Application for a non-material amendment following a grant of planning permission.  
Town and Country Planning Act 1990

SK.15-A1-543-50B, SK.15-A1-543-55A

A30-30, A30-31

Drawing Number:
 SK.15-543-55

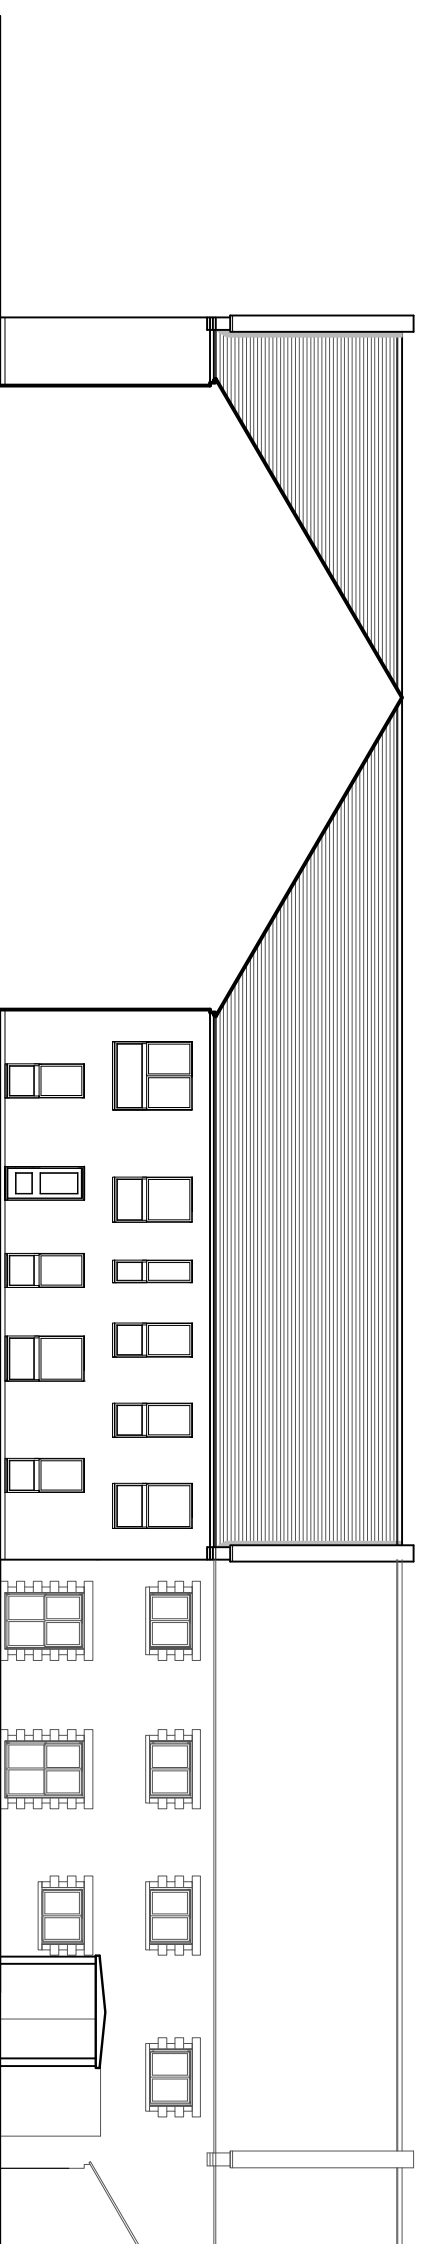
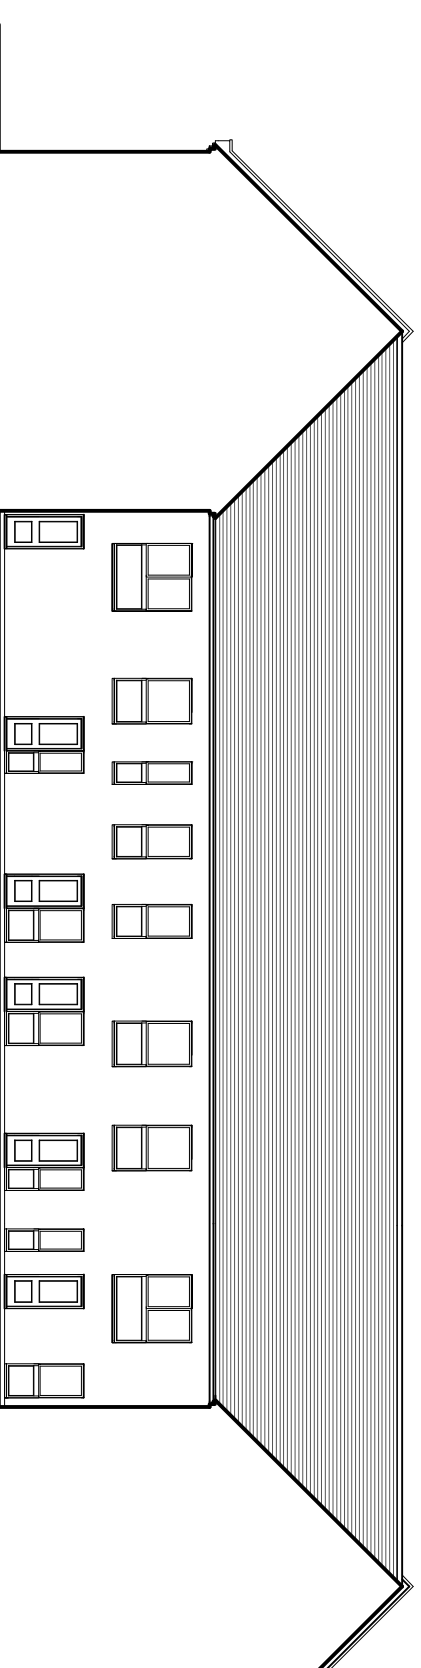
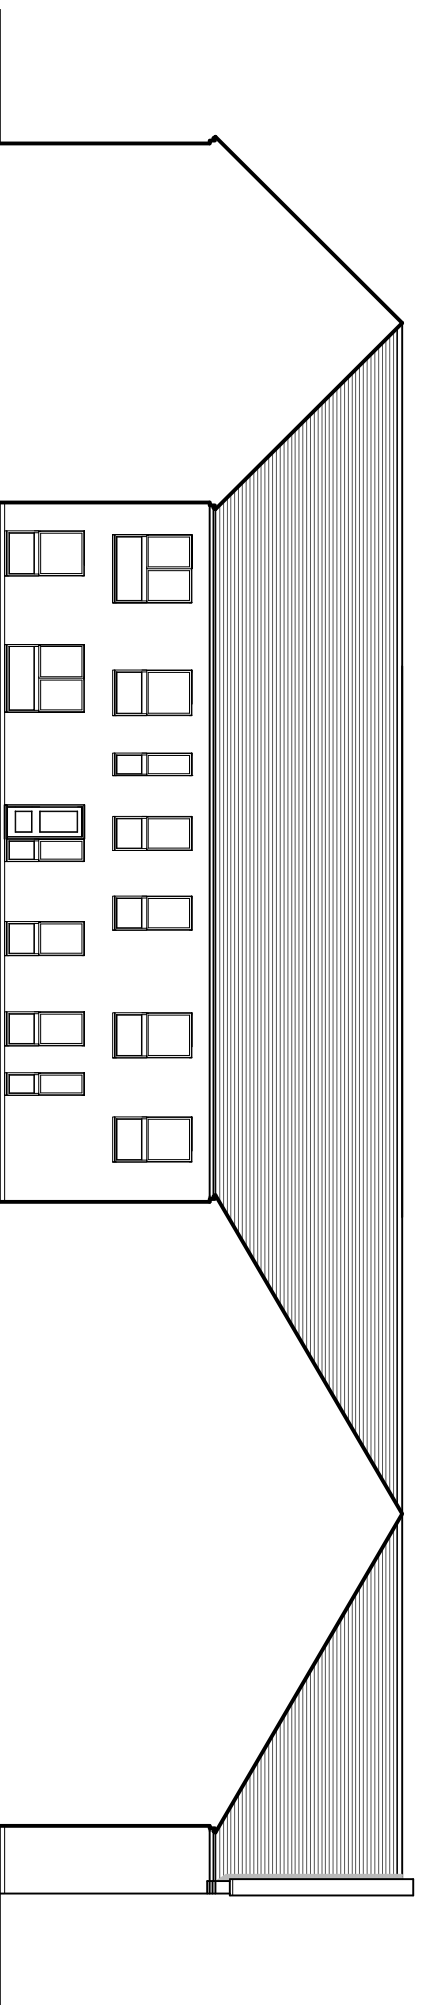
Old plan/drawing numbers:

To improve the appearance of the extension so it is more in line with the existing hotel.

Drawn SA	Date 28.11.2017
Checked KSB	Date 28.11.2017
Scale @A1 1 : 100	
Client BICESTER HOTEL GOLF + SPA	
Project BICESTER HOTEL GOLF + SPA EXTENSION	
Drawing Title PROPOSED COURTYARD ELEVATIONS	
Sheet Status PLANNING	
Project No. IALN17-0083	
Drawing No. A30-31	Rev. B

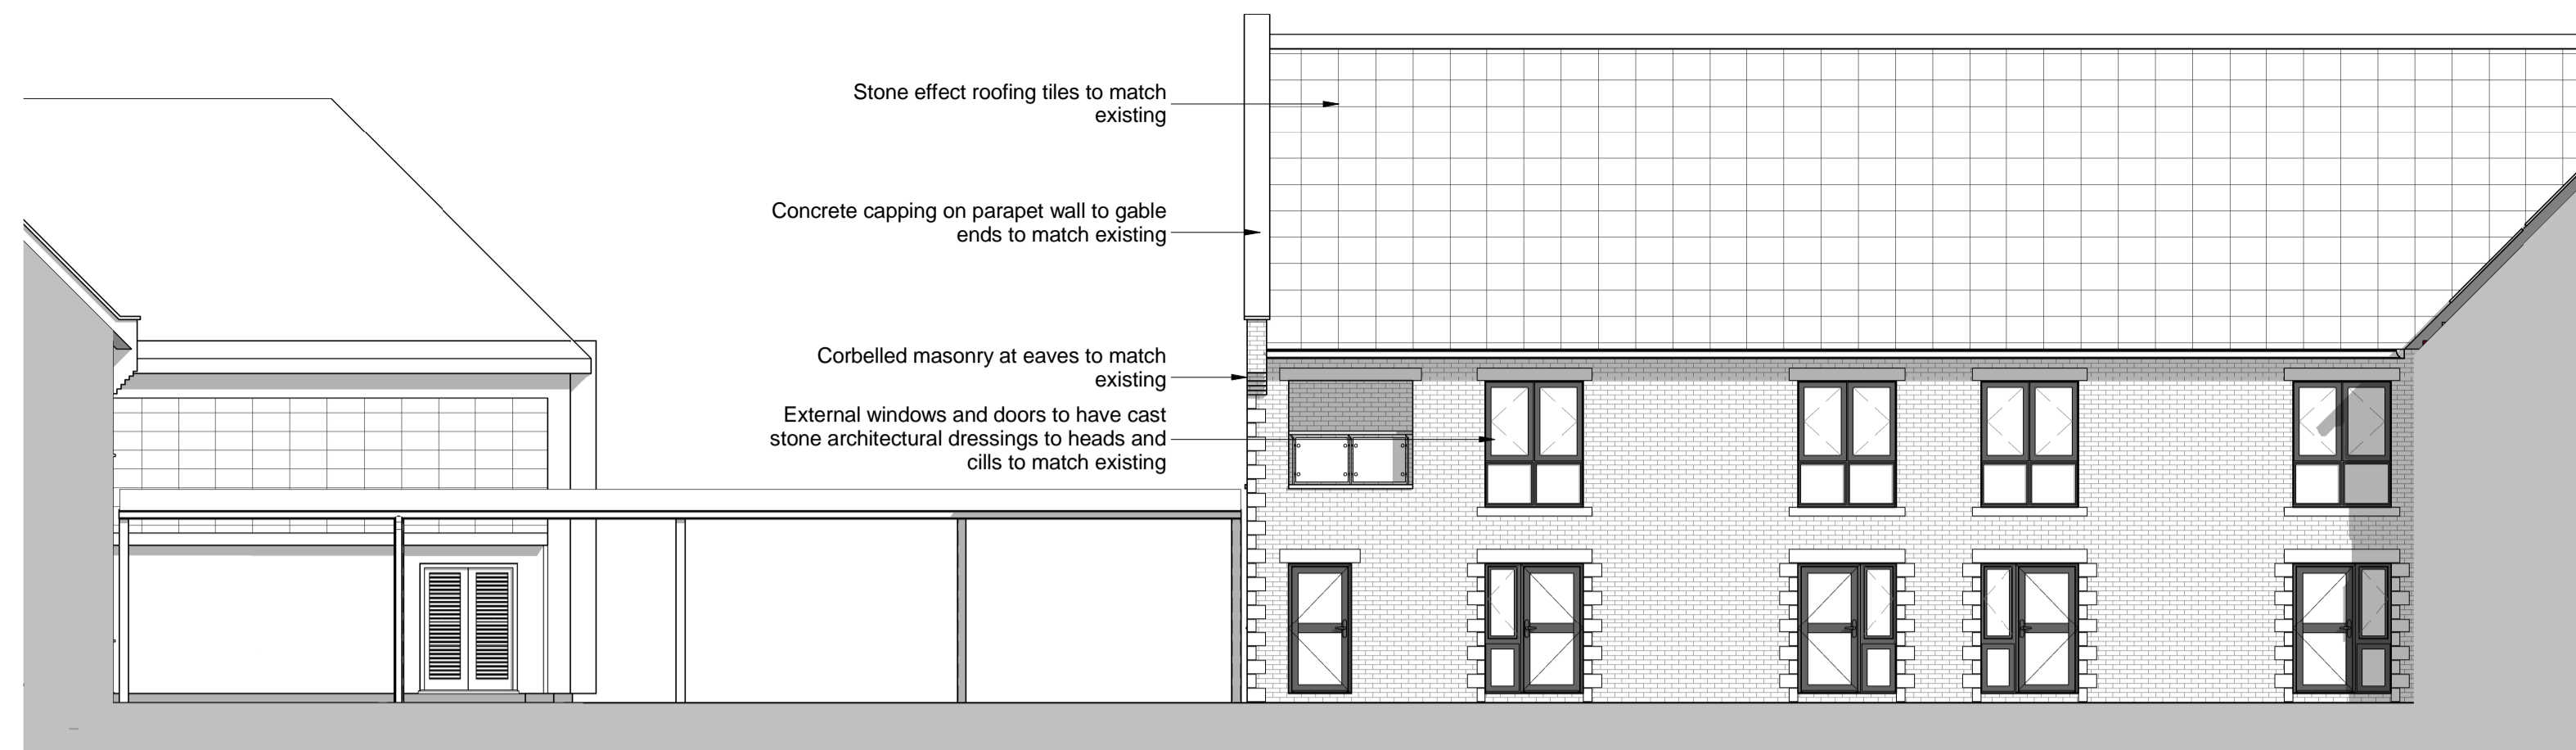
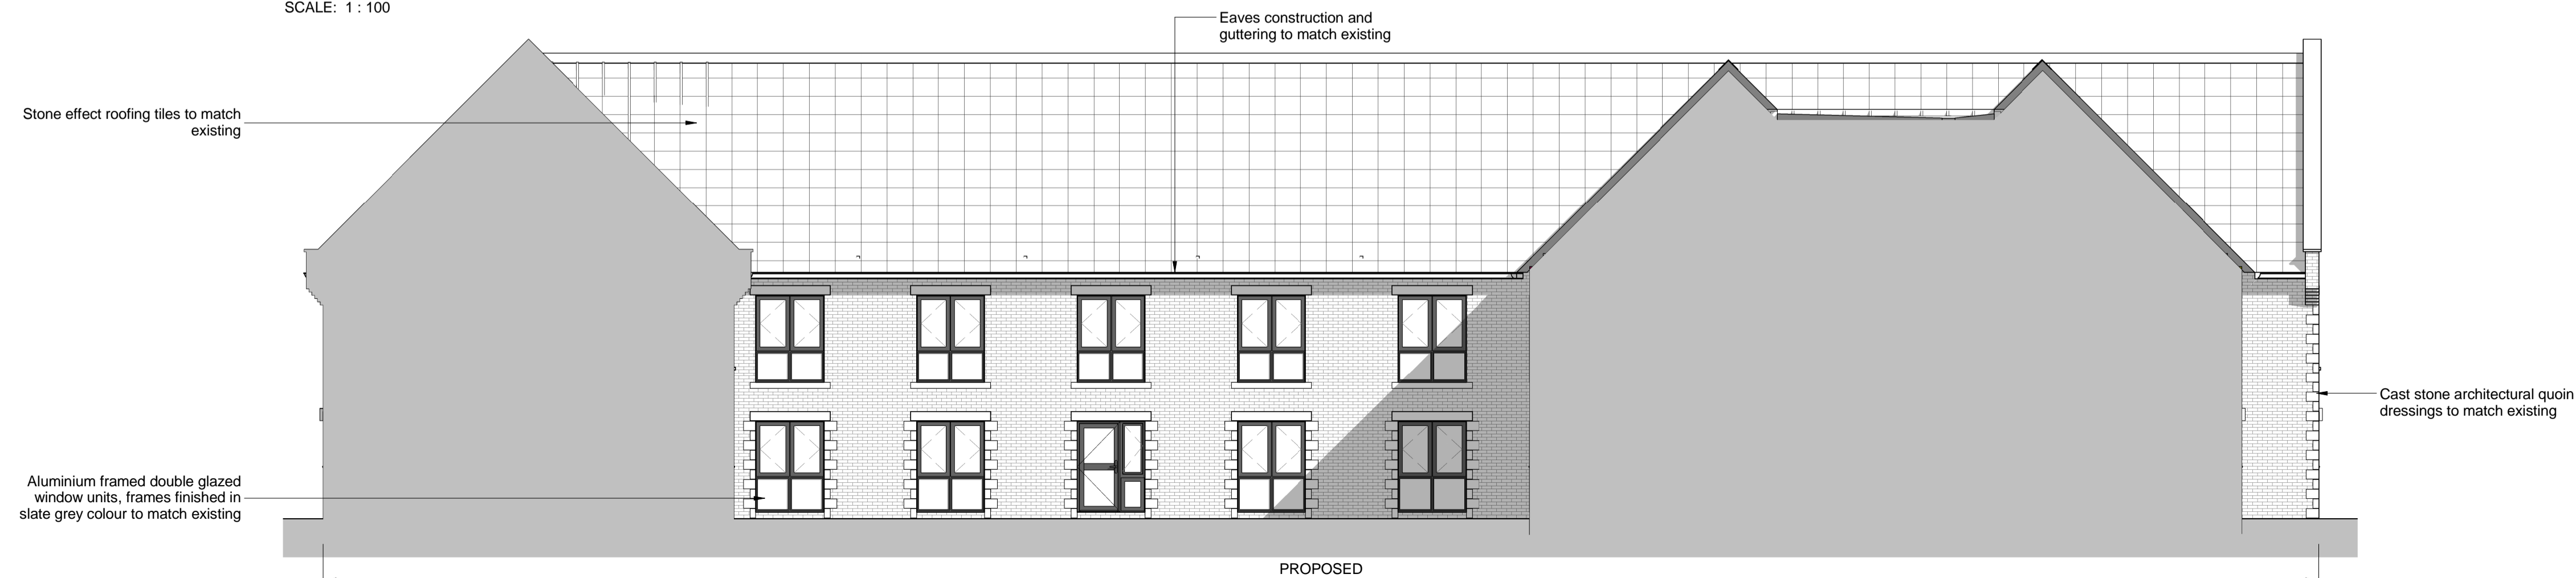
New plan/drawing numbers:
